CITY OF PORTLAND, MAINE

HISTORIC PRESERVATION BOARD

March 21, 2016

Re: 794 Congress Street – antenna and antenna enclosure installation

AT&T MOBILITY FRAMINGHAM, MA 01701		
PROPOSED ROOF & EQUIPMENT PLANS		
DEWBERRY NO.	DRAWING NUMBER	REV
50019239/50066401	C01	1

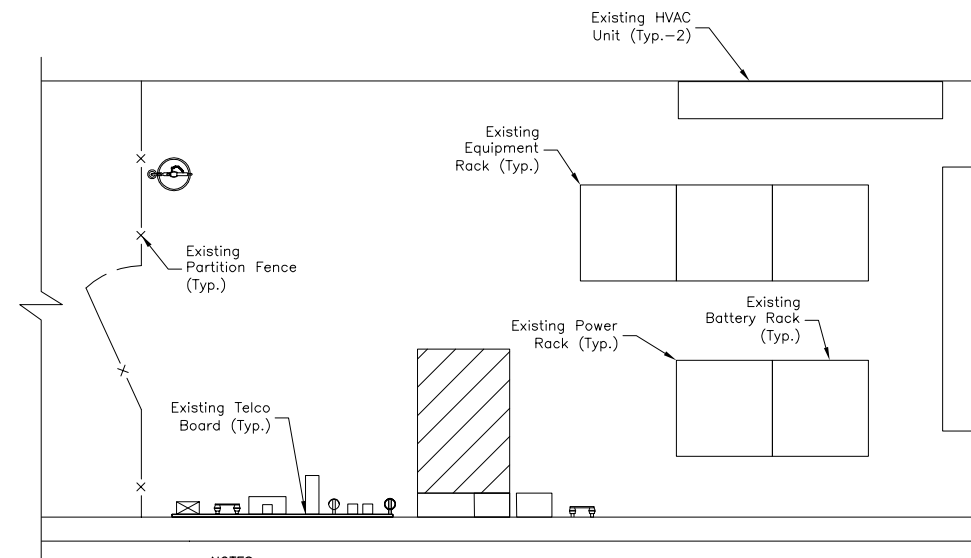
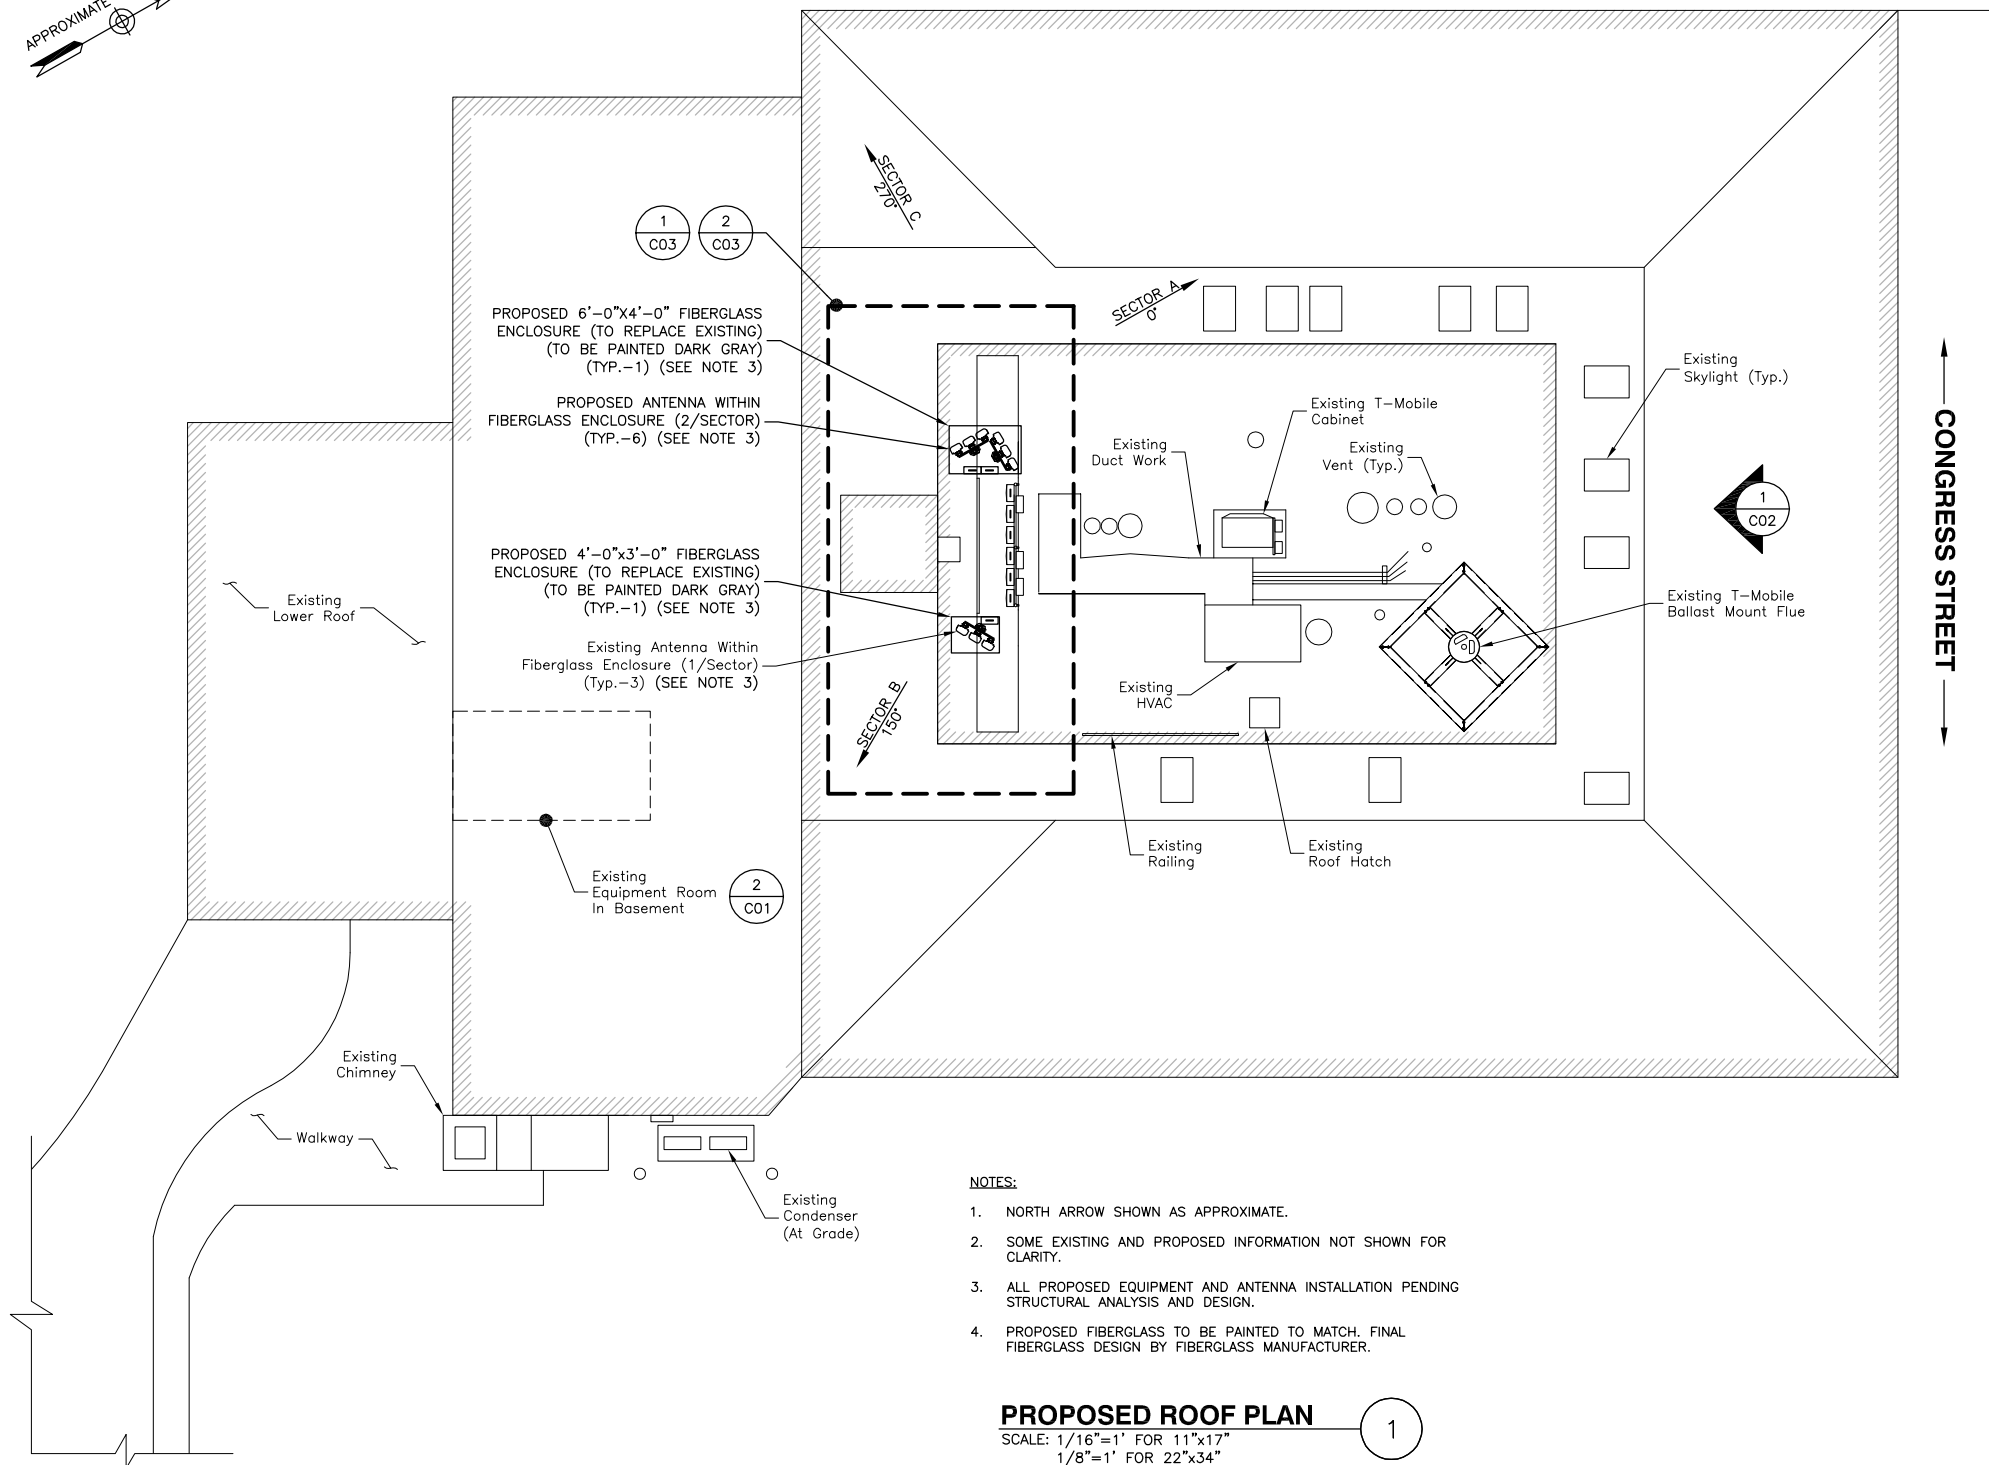
1. Size of antenna enclosures is to be kept as small as possible.
2. Color of antenna enclosures is to be the same recessive color as the rooftop addition on which they are located.
3. Antennas are to be located in the positions represented in the plans dated 1/22/16, to be as far as possible from the existing elevator shaft extension.
